**Consultation Response from KC,
Lead Local Flood Authority**

2026/91615 Land off, Roslyn Avenue, Netherton, Huddersfield, HD4 7EW

Date Responded: 06/07/2026

Discharge of Drainage Conditions

Proposed Attenuation Long Tank Details

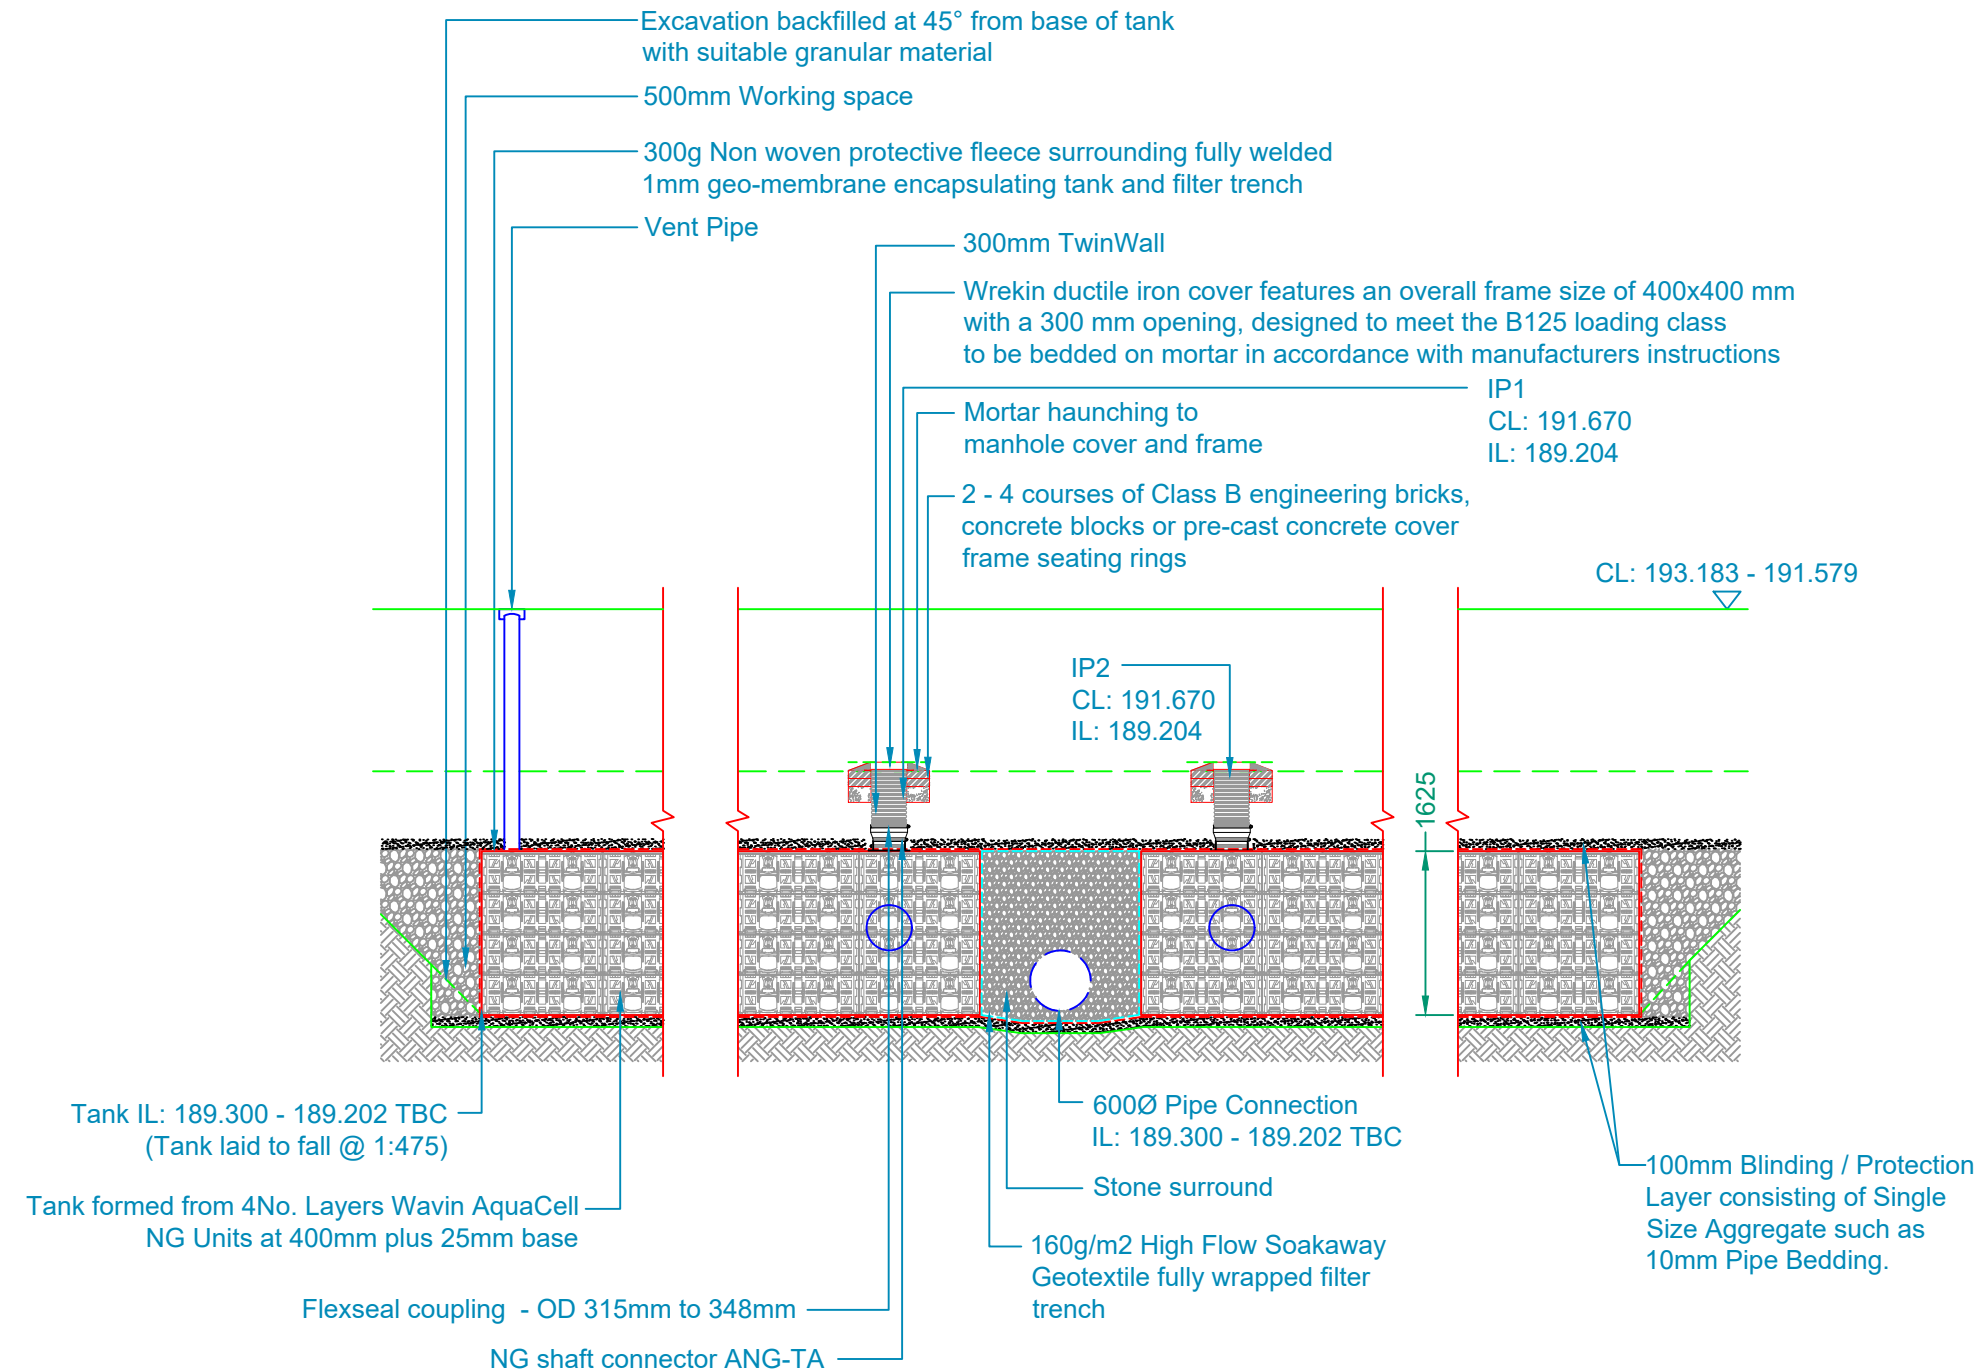
MH S21 should be of the catch pit type to reduce the risk of siltation in the attenuation tank. Means of access into the tank for inspection and maintenance should be provided together with a Maintenance Schedule for the tank, flow control device, gullies, etc. as set out in Condition 21

Therefore Condition 21 **cannot be** discharged until details of tank access, and the Maintenance Schedule have been submitted to the LPA for approval.
